PLANNING CONSULTATION RESPONSE

| Application No | 2025/0908 |
| Proposal | Re-engineering and Restoration of Yew Tree Quarry through the importation of non hazardous Excavated Soil Materials. |
| Consultee | Edward Jowett (Tree Officer) |

Proposed Site Access Arrangements

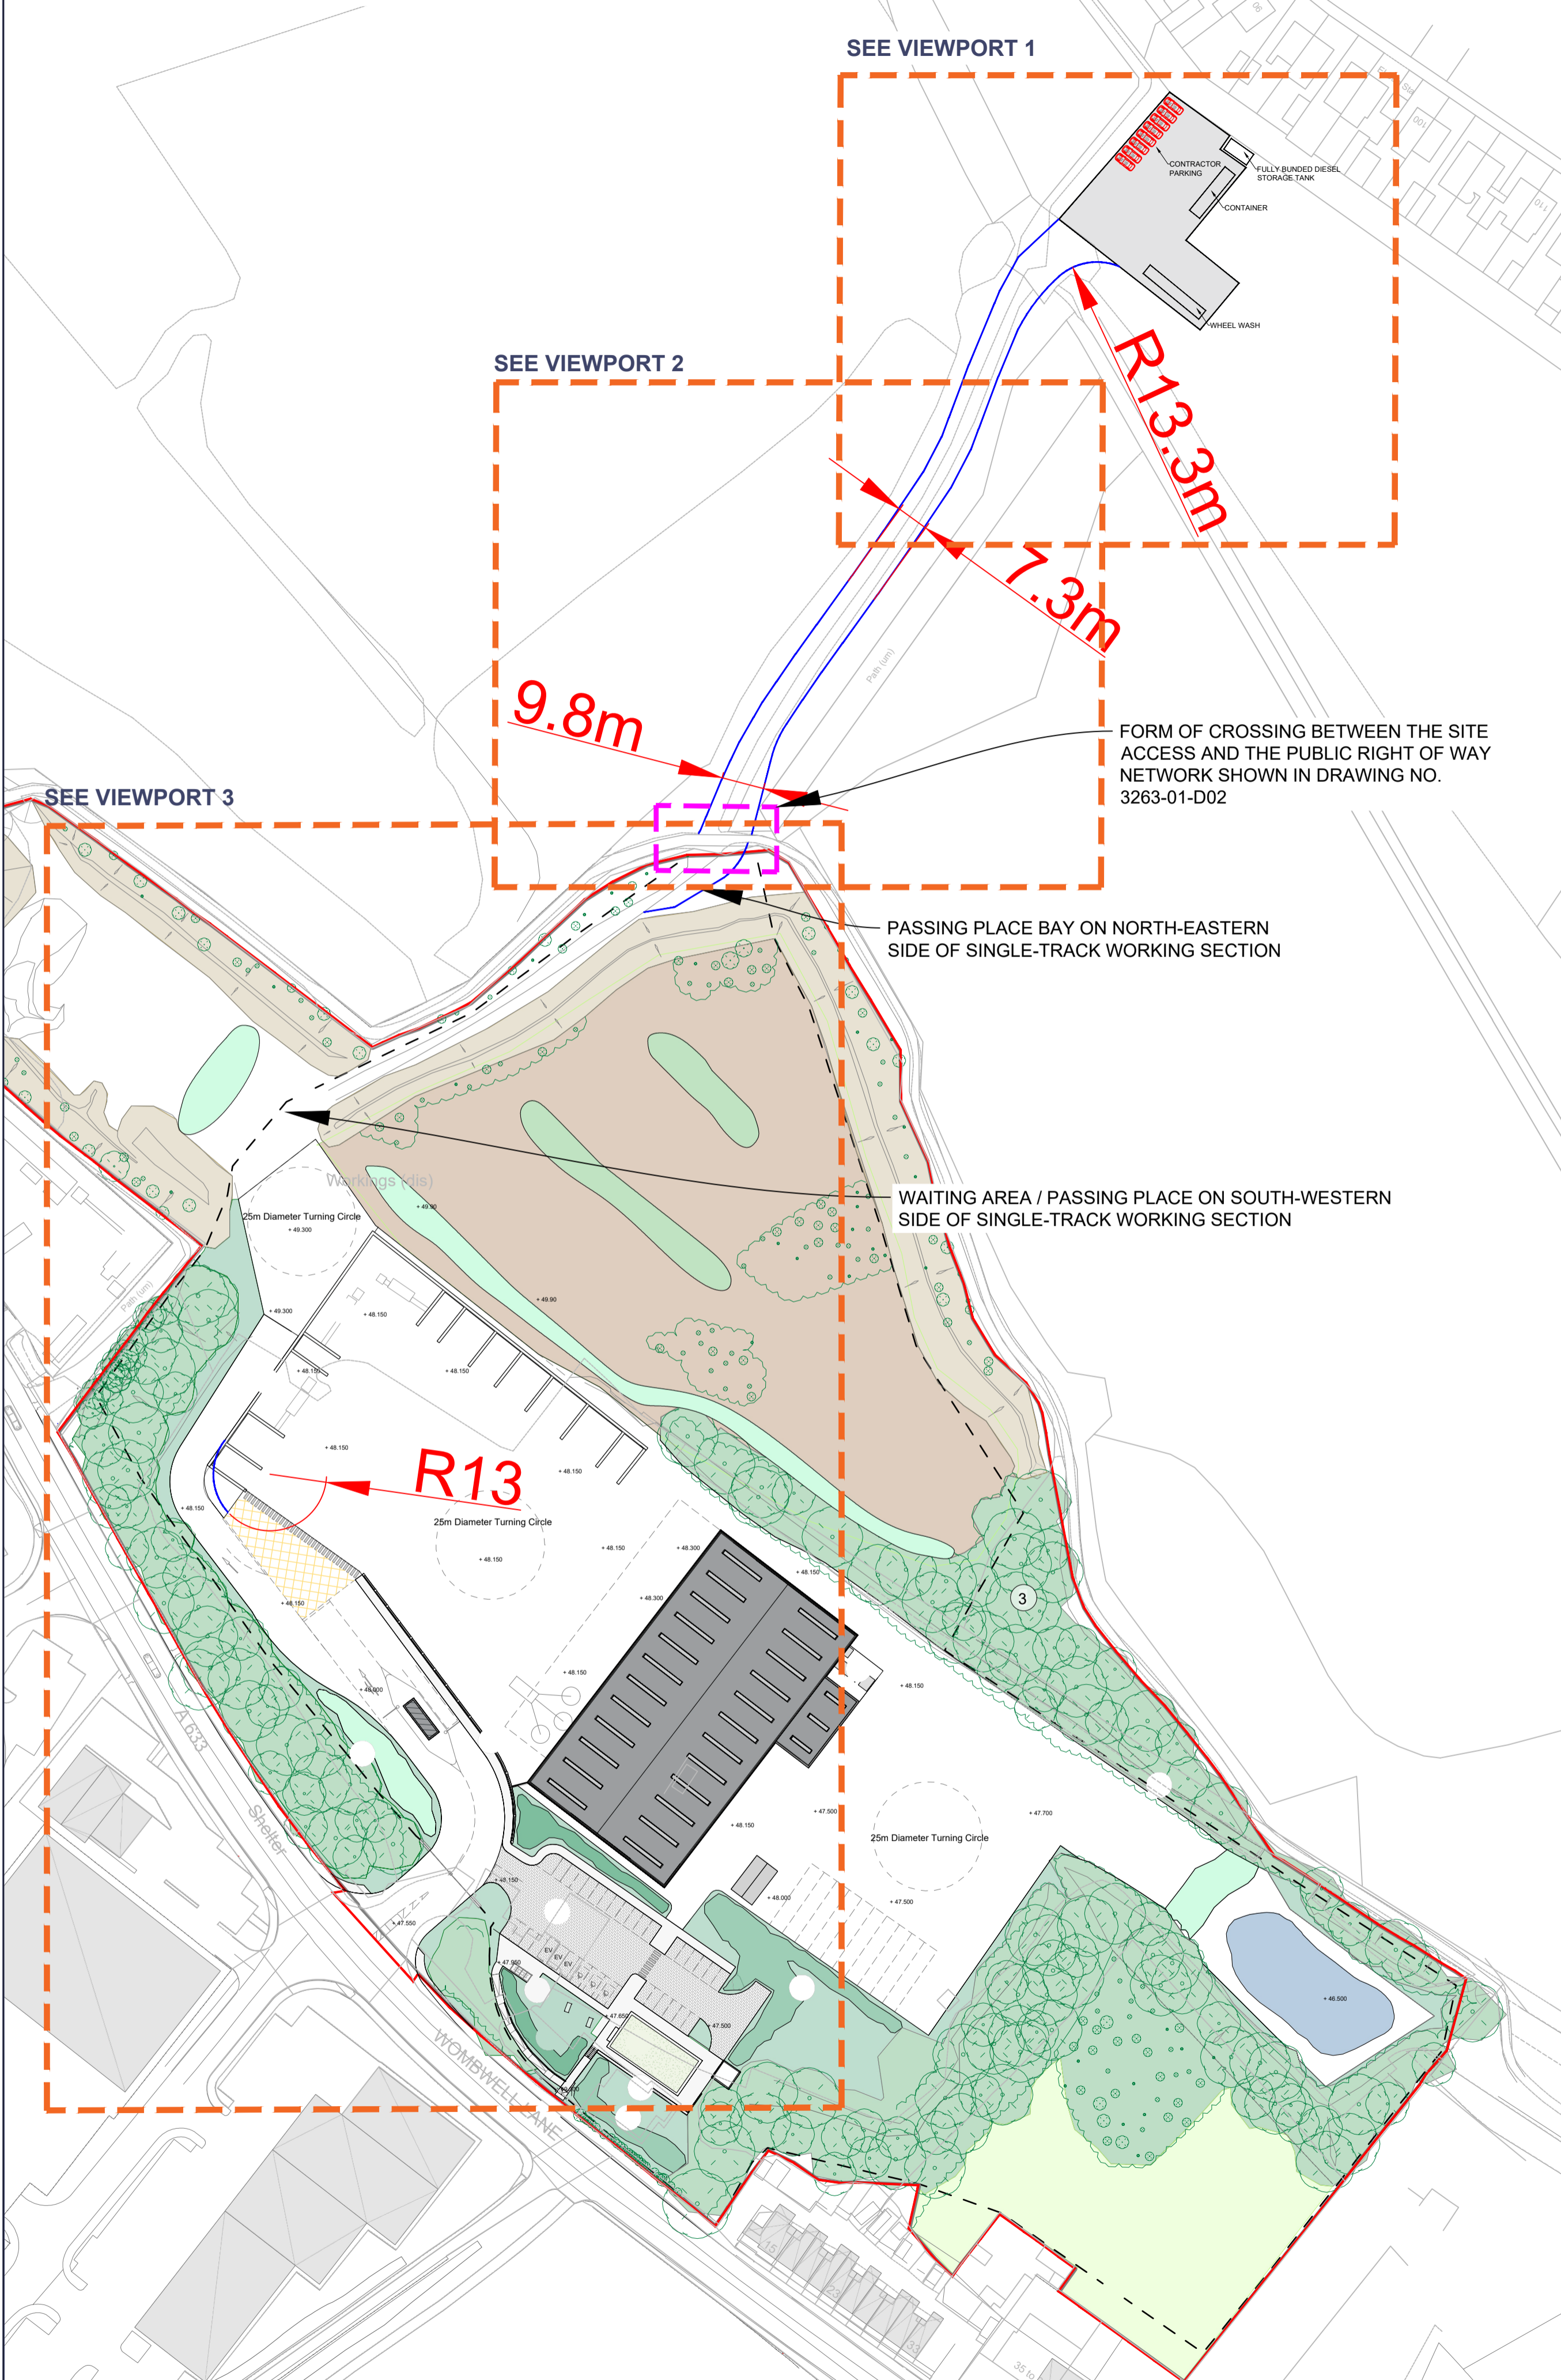
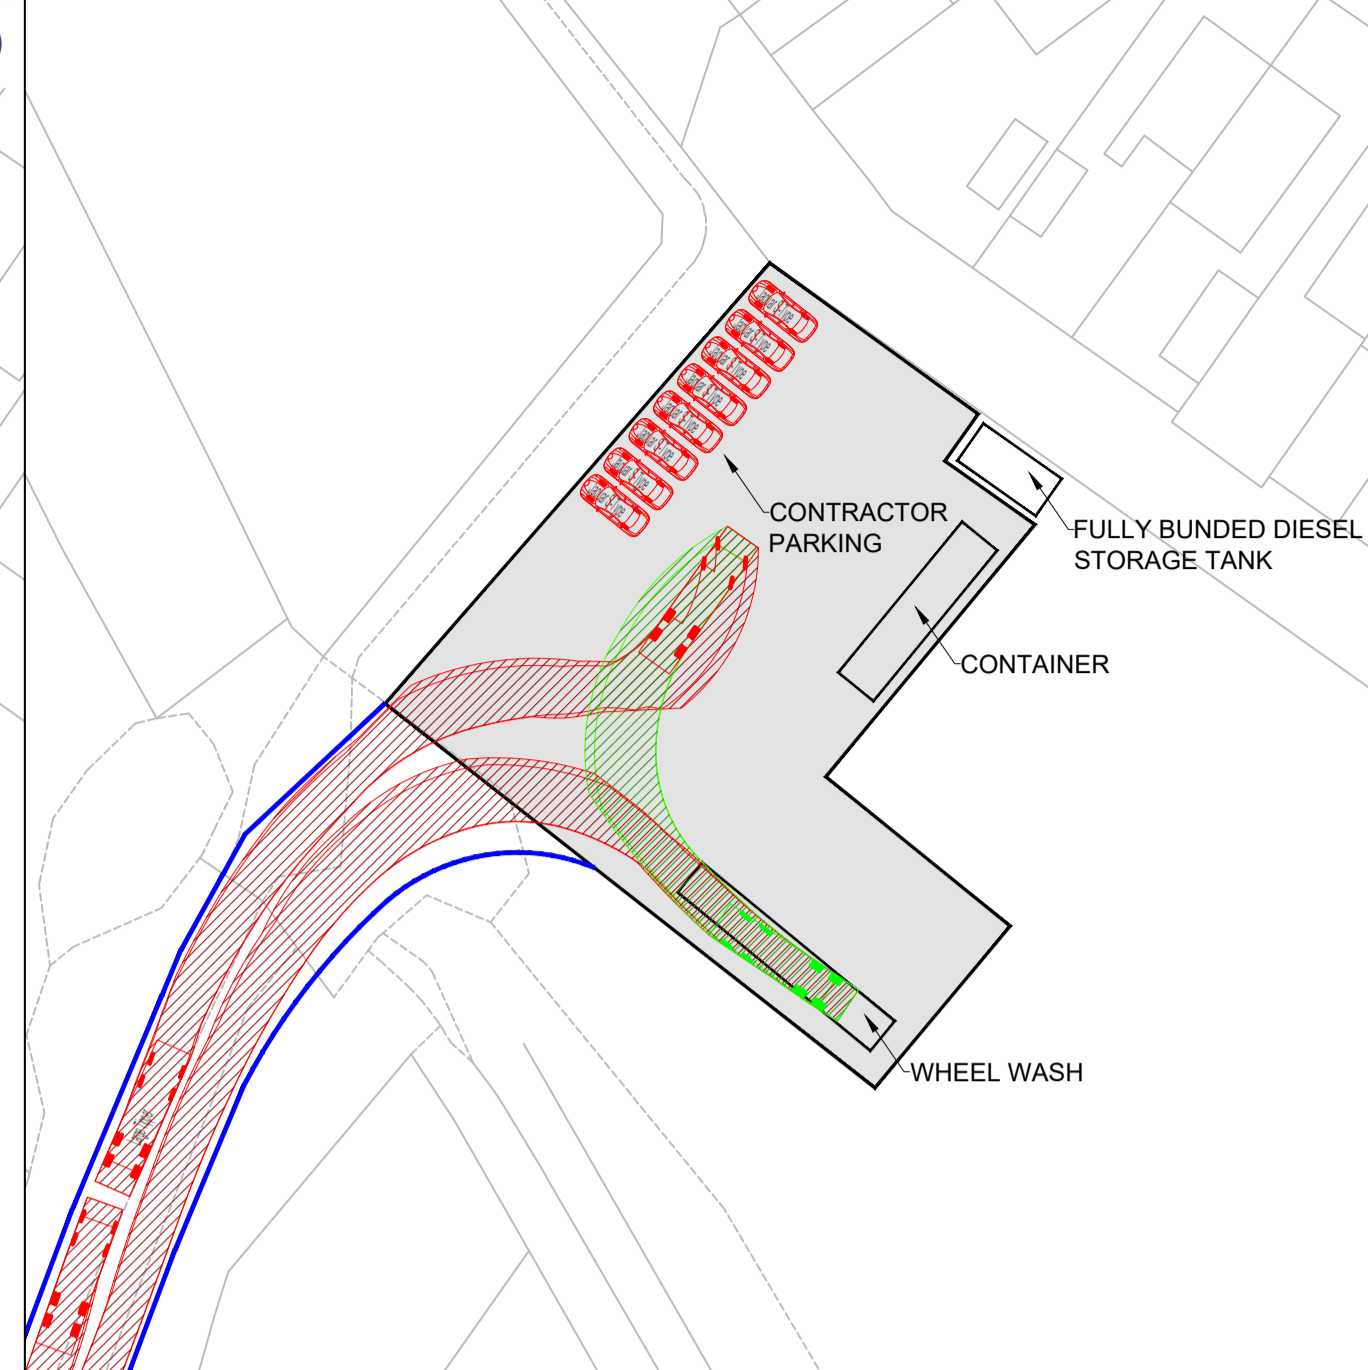
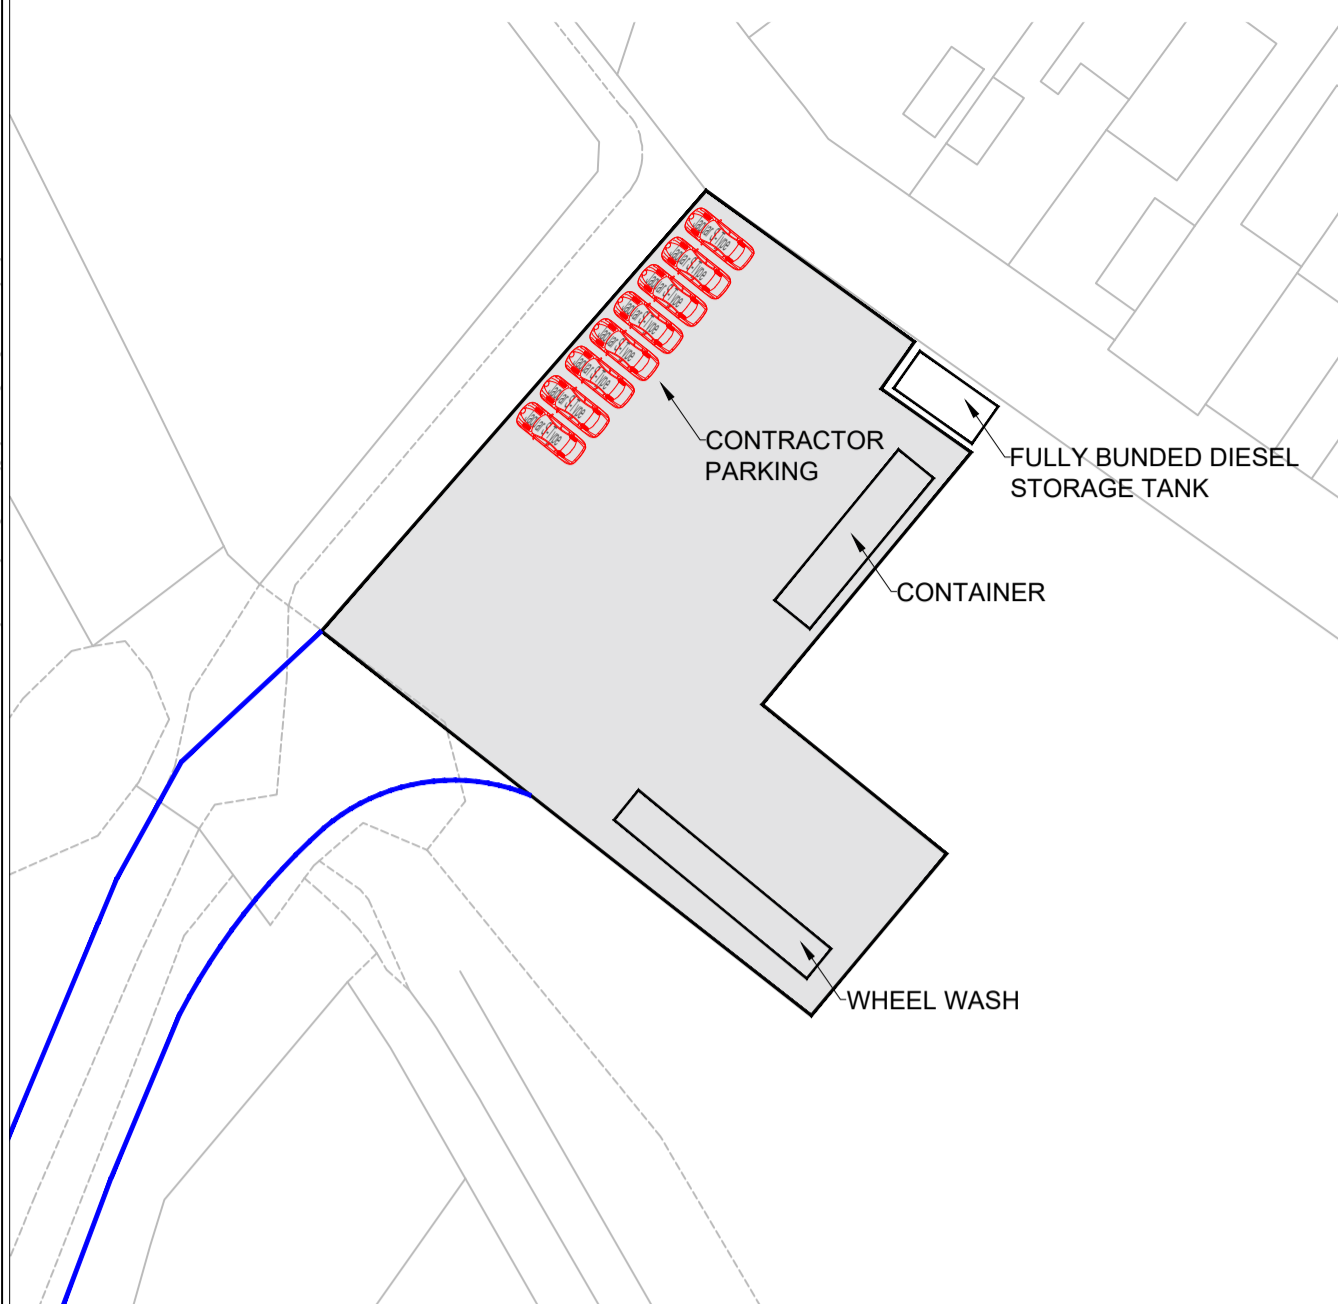
With regards to the access and site compound I note that tree removals will be required, however the exact tree removals and retention are not really dealt with as the trees have been surveyed as large groups in the main. I would therefore ask that more detailed survey works are undertaken in areas where there are potential impacts on trees to allow for a more detailed representation of what will be removed and retained and how retained trees will be impacted. I would also reiterate, given the additional survey works requested, that the tree survey information needs to be used to inform the final proposals put forward to minimise any impacts on the trees.
